Recommendation Report for Planning Permission for Works or Extension to a Dwelling

REF NO: AW/46/22/HH

LOCATION: 53 Gossamer Lane
Aldwick
PO21 3DD

PROPOSAL: Single storey rear extension.

A	20-02-2022	Planning Issue	CE
REV	DATE	AMENDMENT	BY
PROJECT			
53 GOSSAMER LANE ALDWICK WEST SUSSEX, PO21 3DD			
DRAWING			
PROPOSED PLANS SINGLE STOREY REAR EXTENSION			
Date	FEBRUARY 2022	Drawn By	CE
Scale	1: 50 @A1	Iss. App. By	SK
Drawing No	007A	File Location	093

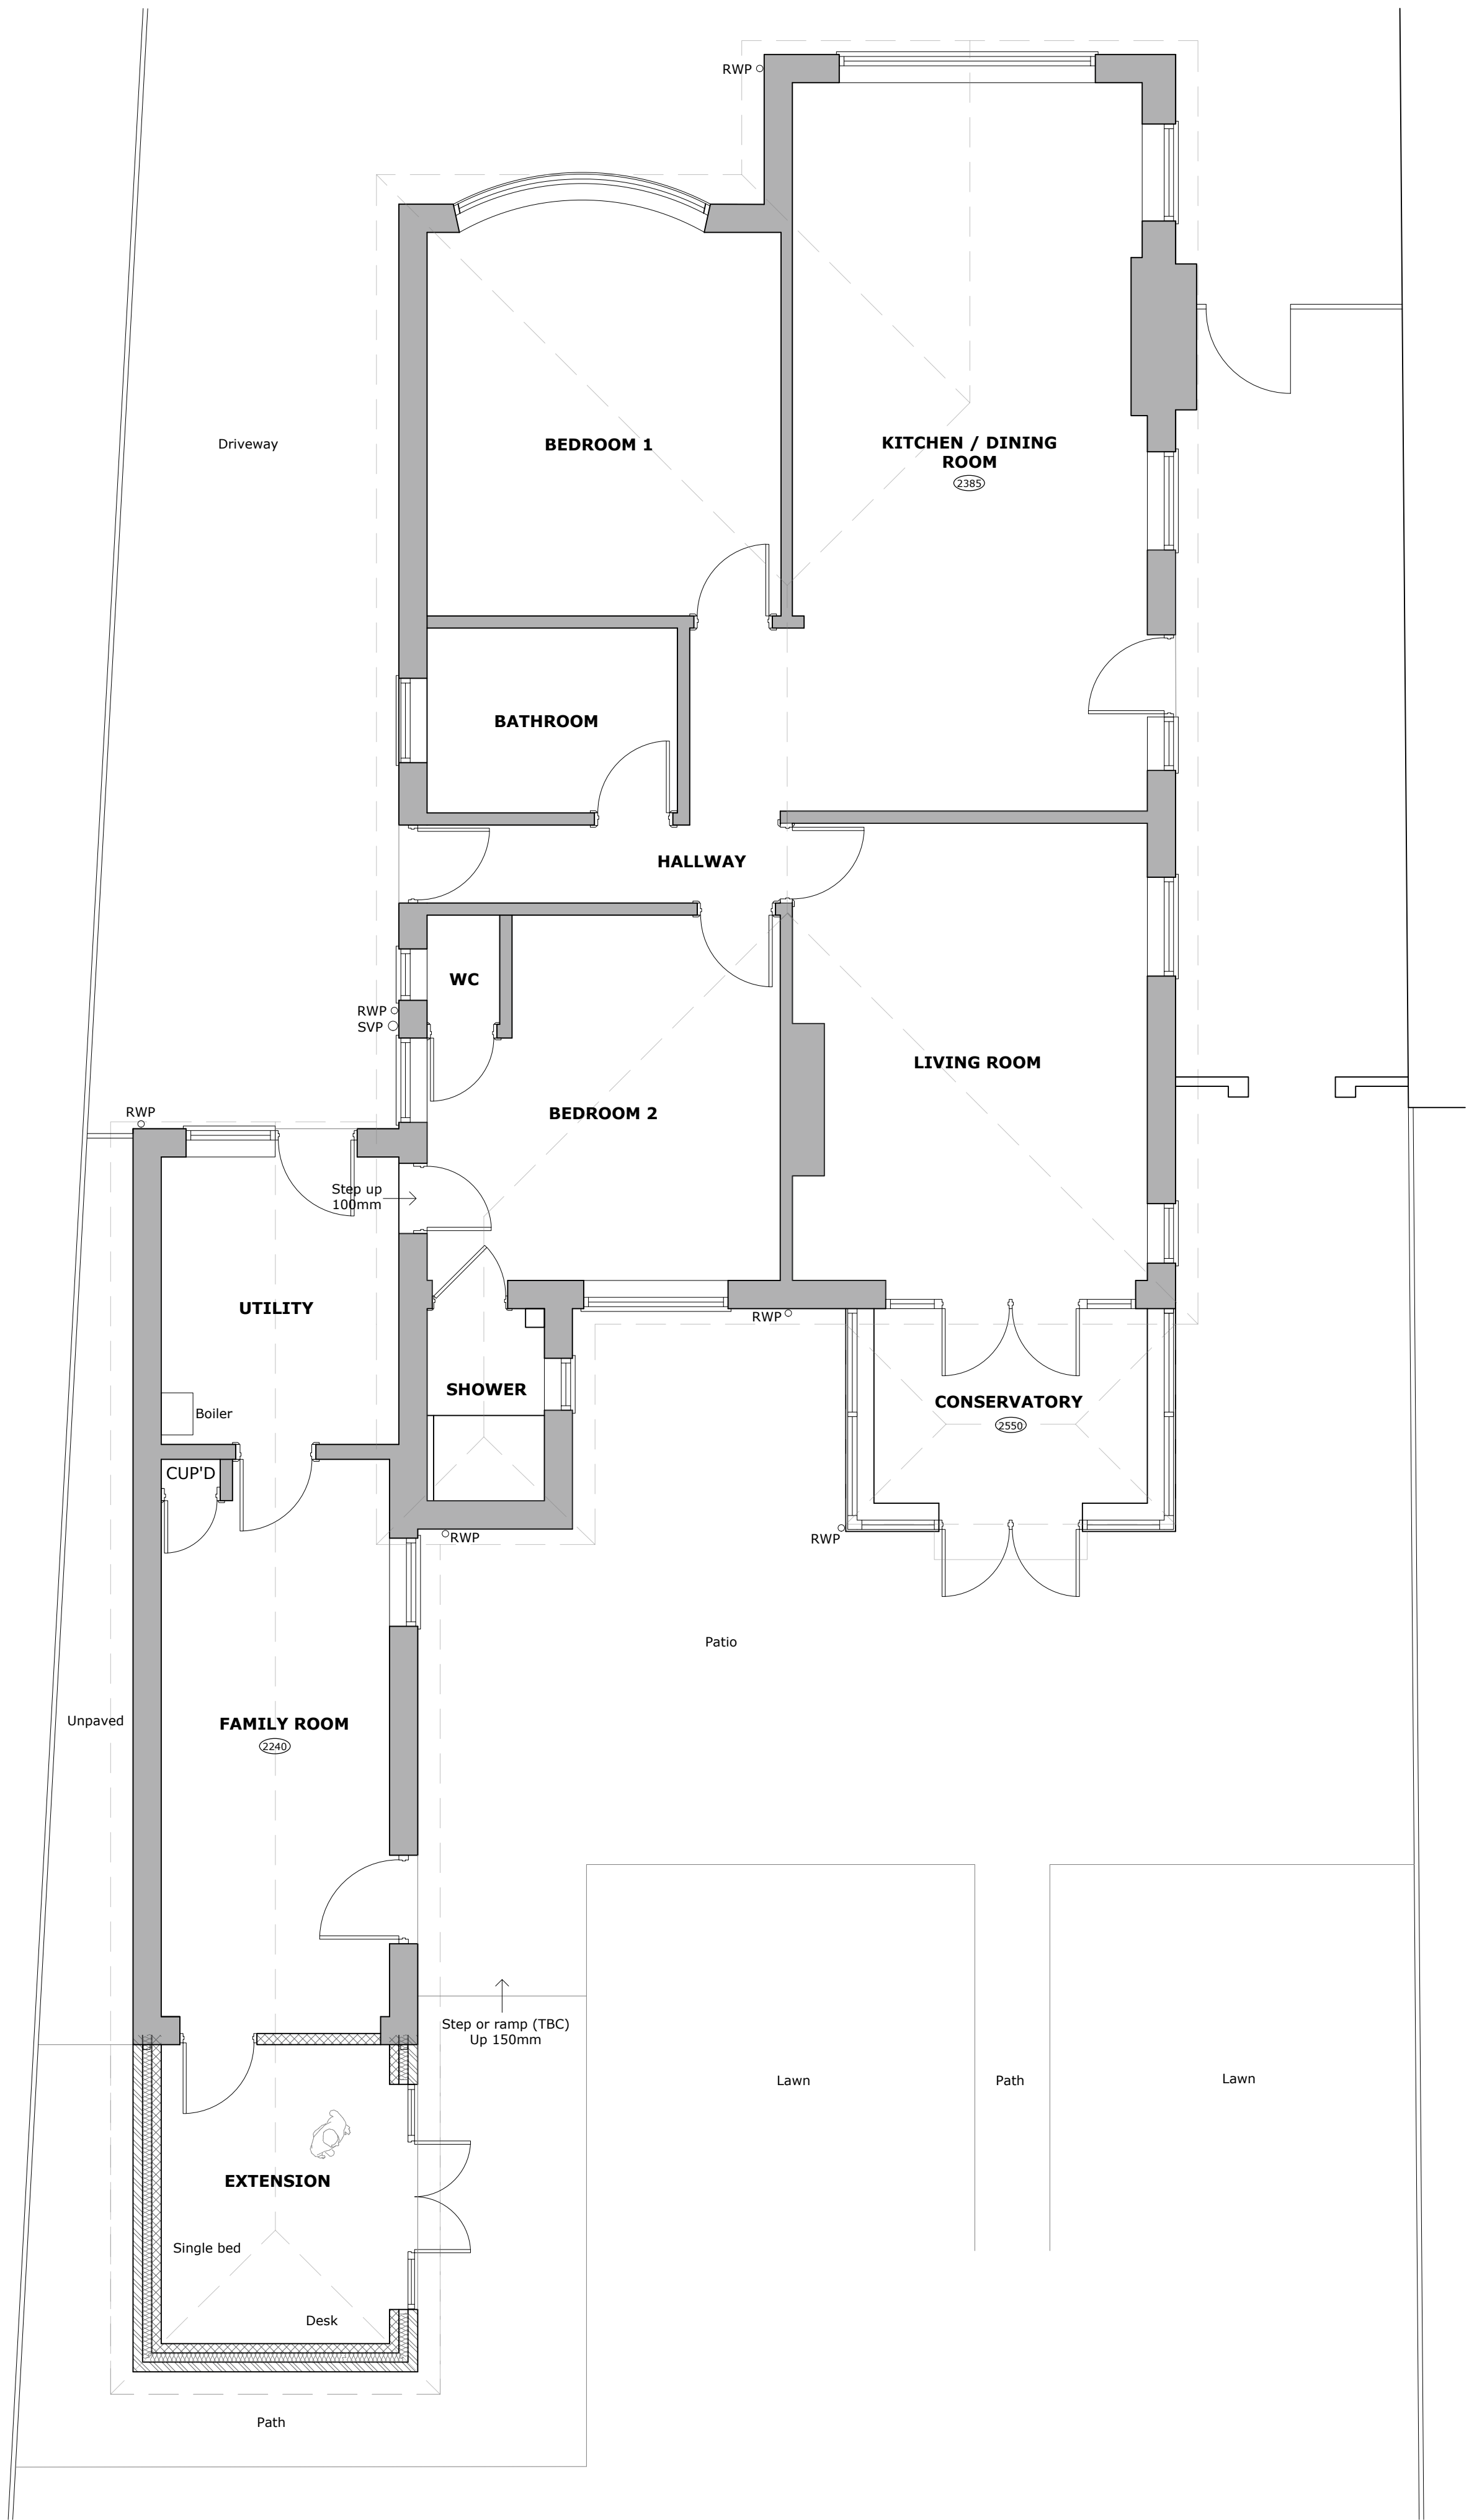
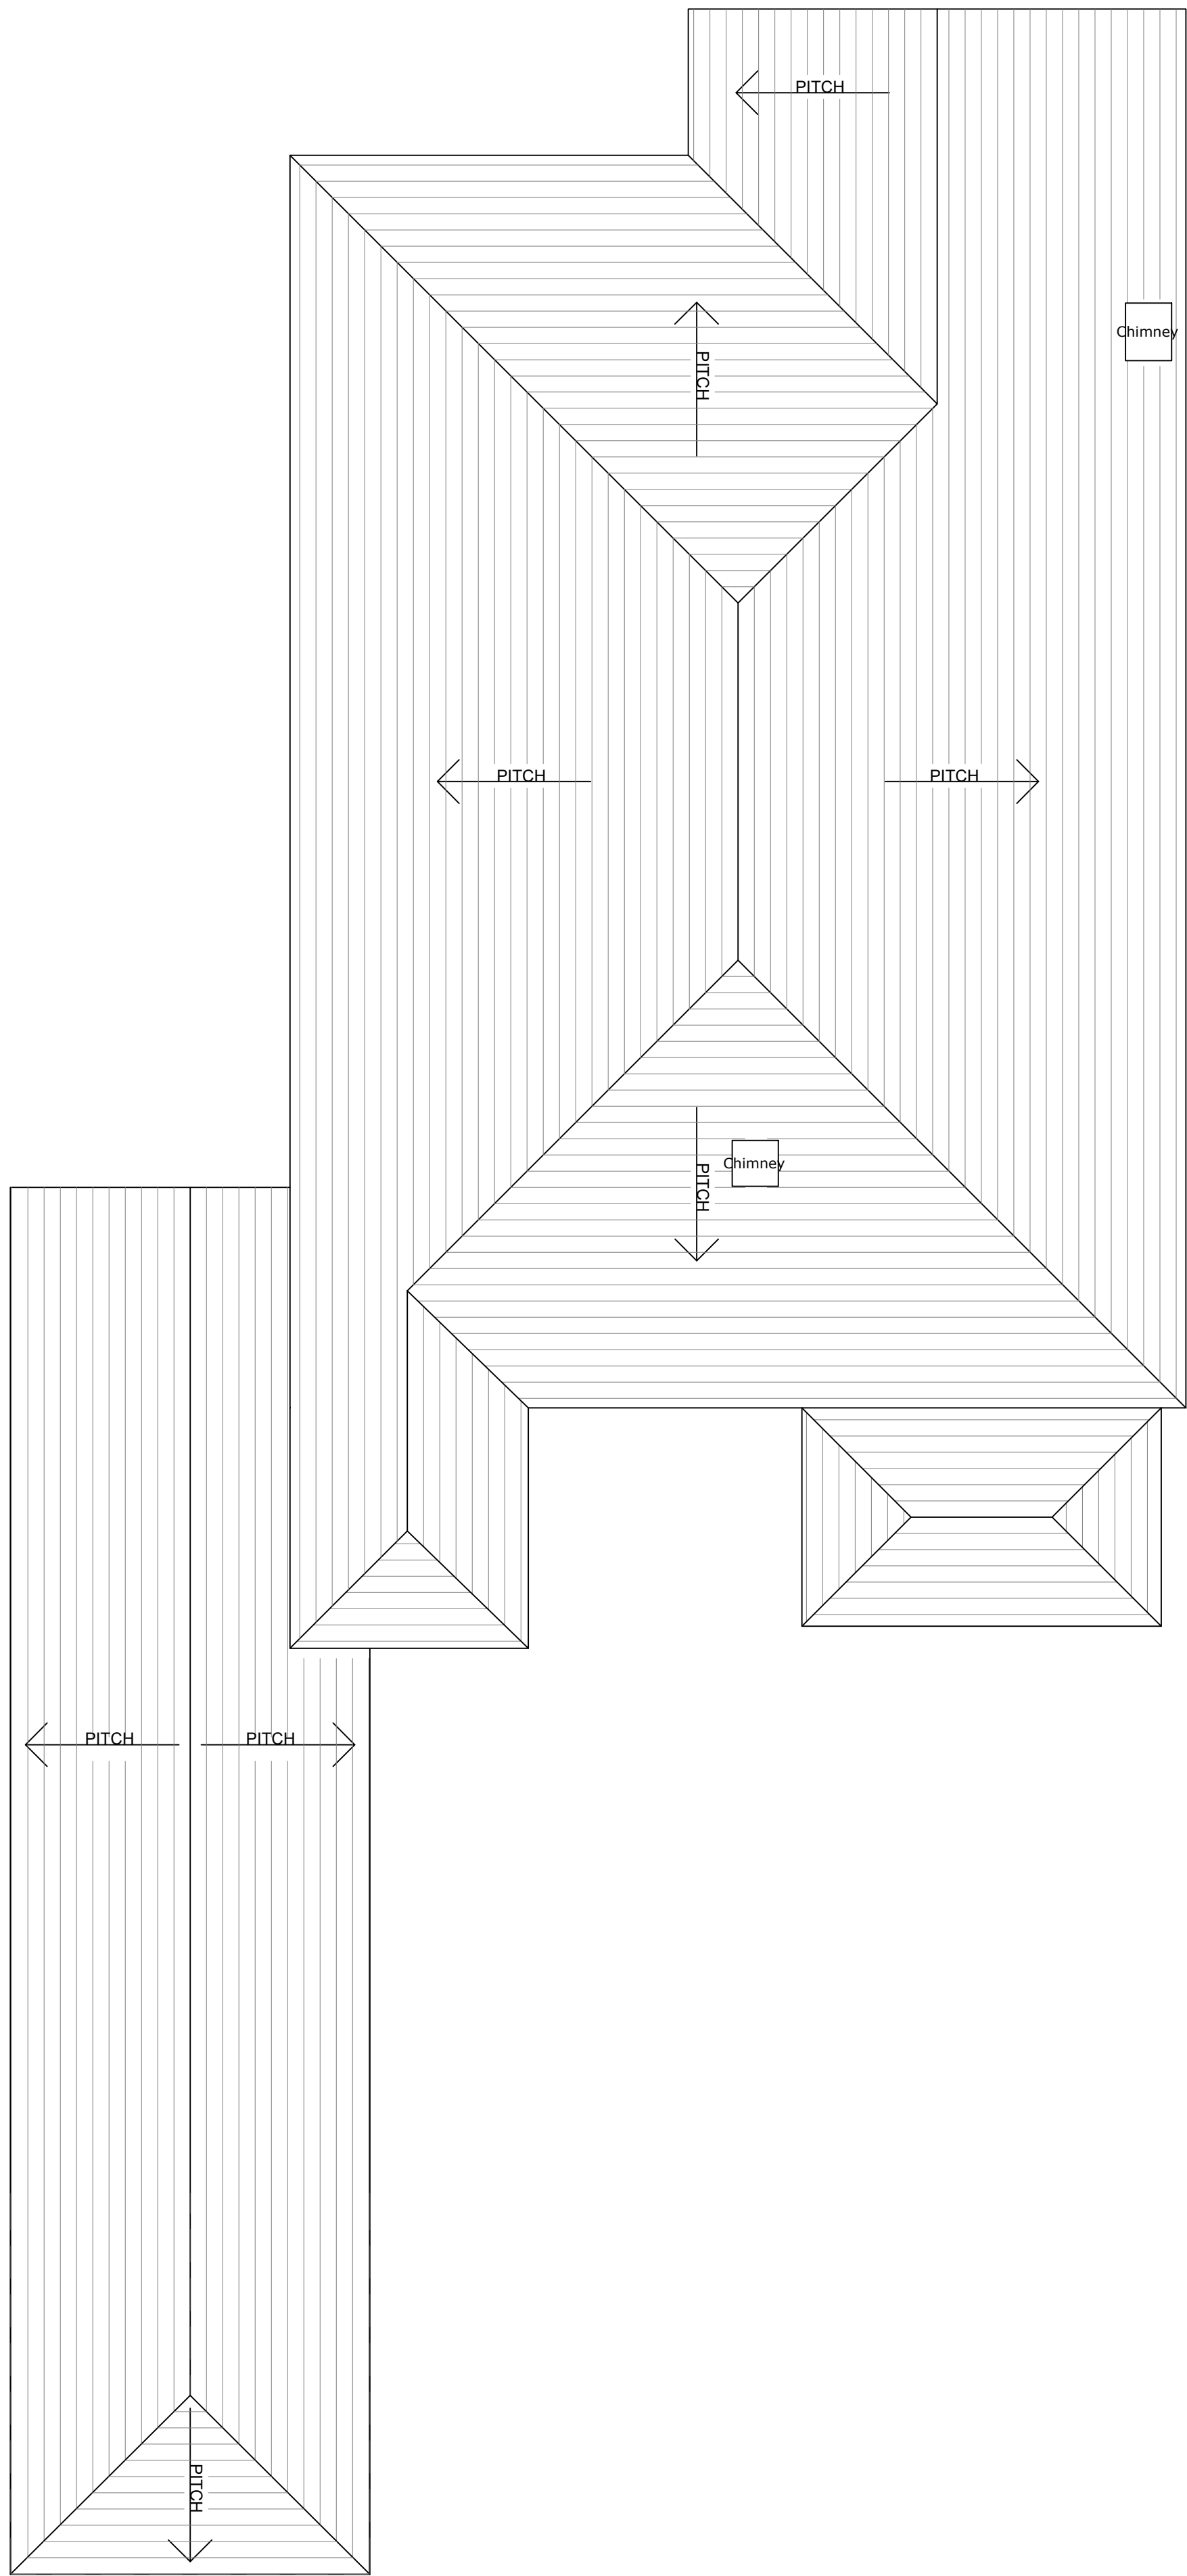
The extension will have a depth of 3.5m and a width of 3m joining to the end of an existing extension on site.

The proposal does marginally intersect a 45 degree angle when drawing a line from the closest window to the boundary of No.57 however does not interest a 60 degree angle. Whilst the development extends some distance beyond the rear building line of the neighbouring property at No.57, due to its modest size and its location with 1.2m retained to the boundary, the development does not appear adversely
